Comments from Greenspace

Subject: Planning Consultation on: BE/18/17/PL

Site Address: Land west of New Barn Lane Bersted

Description of Works: Variation of condition 3 for approved plans & 23
for vehicular access imposed under
BE/142/15/OUT.

Land to the West of New Barn Lane,
North Bersted
Illustrative Masterplan-For Support
for Landform Estates Ltd.

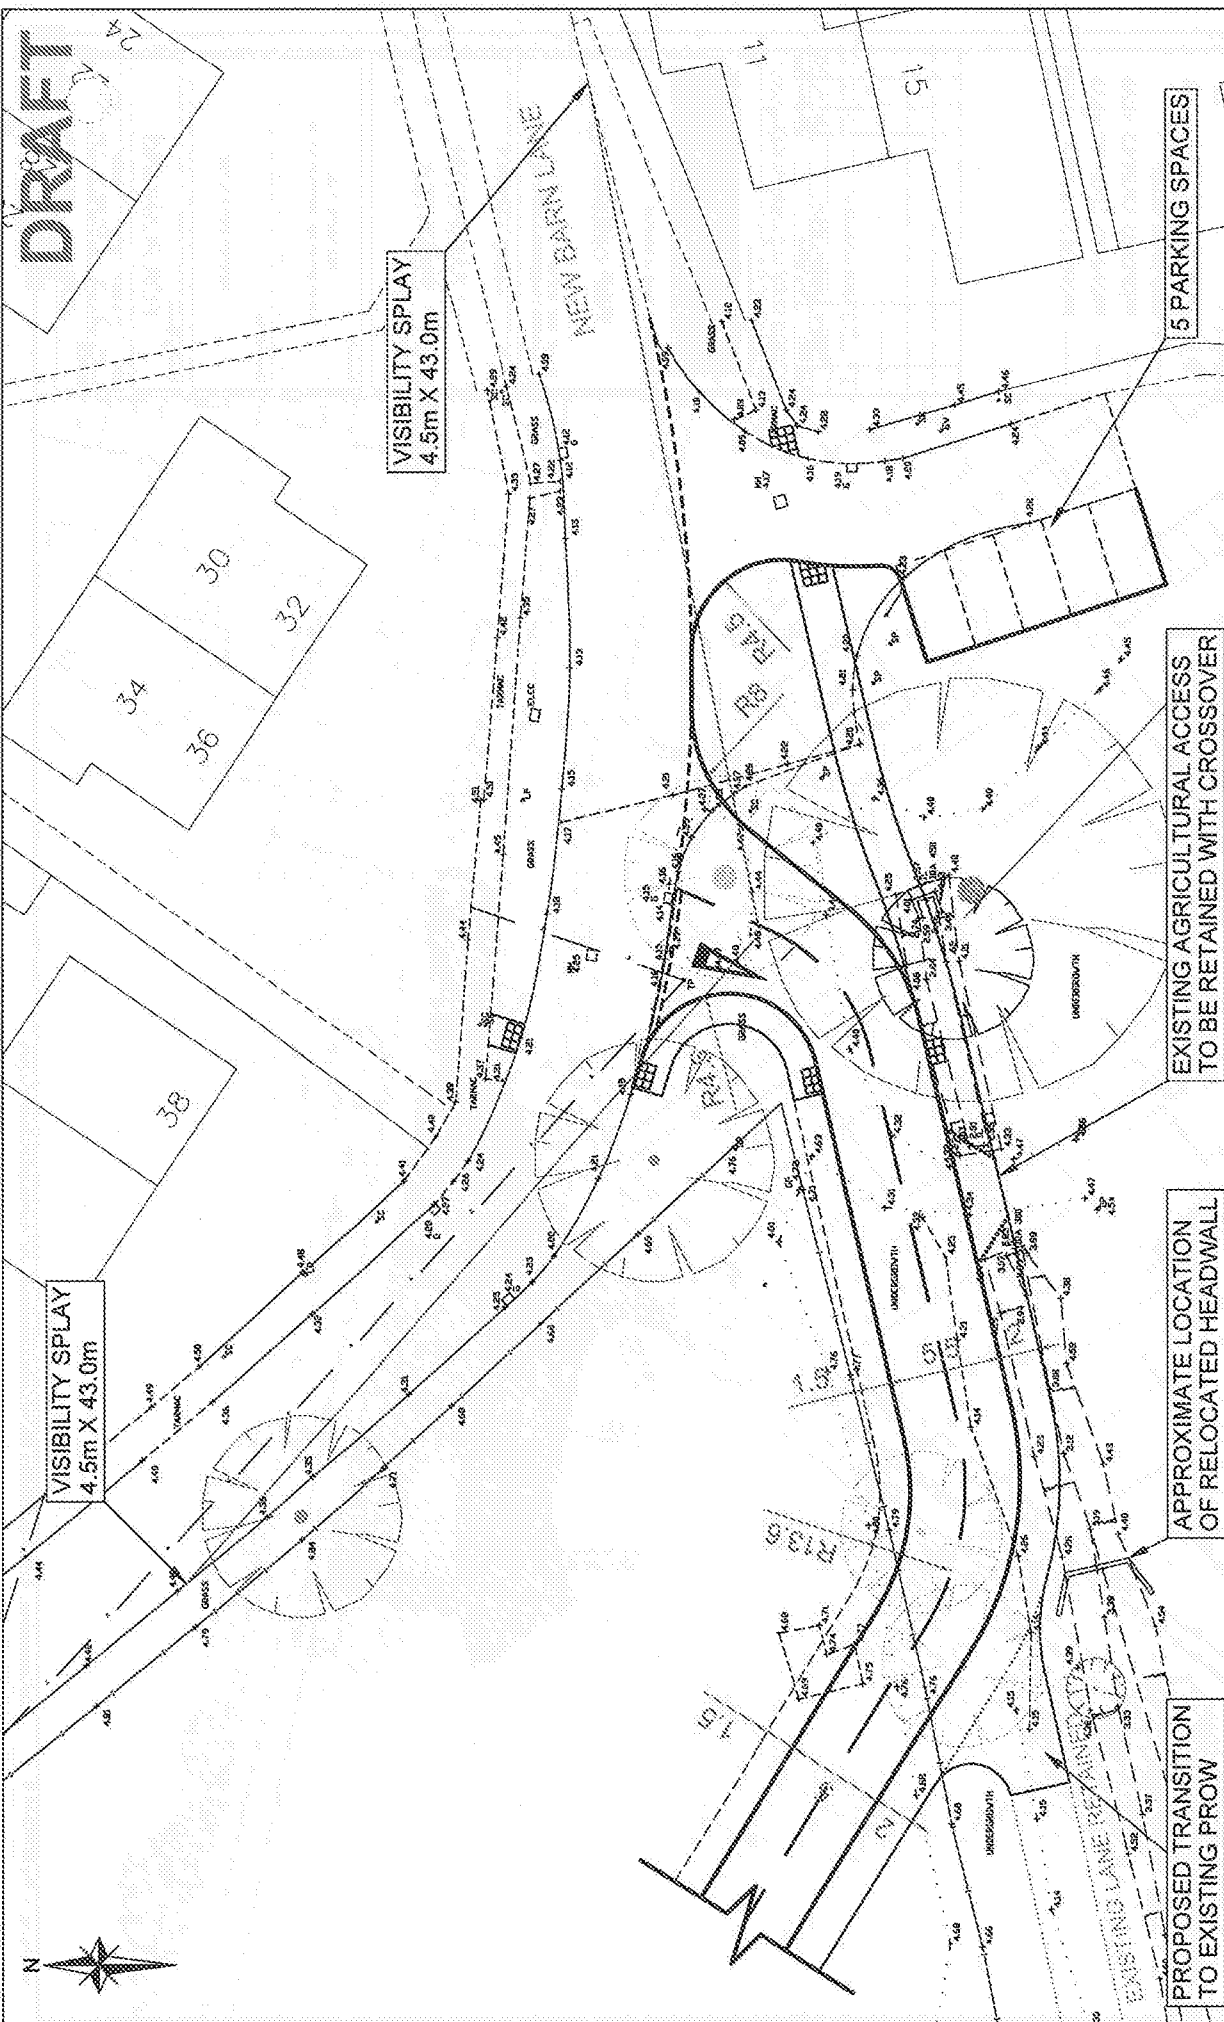
The new layout would not appear to compromise the significant existing trees in this location, which have been indicated to remain. We would however require that careful consideration be given to the correct RPA (root protection areas) for these trees, both before and during construction in order for these trees to remain undamaged going forward.

A revised landscape scheme (beyond the indicative masterplan) would need to be submitted and approved, detailing the revised access into this development and any mitigation if deemed necessary. 'Forming part of the application a full landscape scheme should be submitted for approval, detailing species choice, position, densities and size at time of planting. This should be plotted in plan and list form and in relation to the trees and vegetation to be retained in the locale, so that a clear picture of the proposals can be seen. These details are required to assure the adjacent land setting is maintained, the setting is uncompromised and the proposals are appropriate to its setting. The illustrative masterplan does set back the dwellings from New Barn Lane and details a central open space area which would create a useable and desirable space. The retained vegetative areas to the periphery of the site would create wildlife corridors and for the retention of valuable established vegetation.'
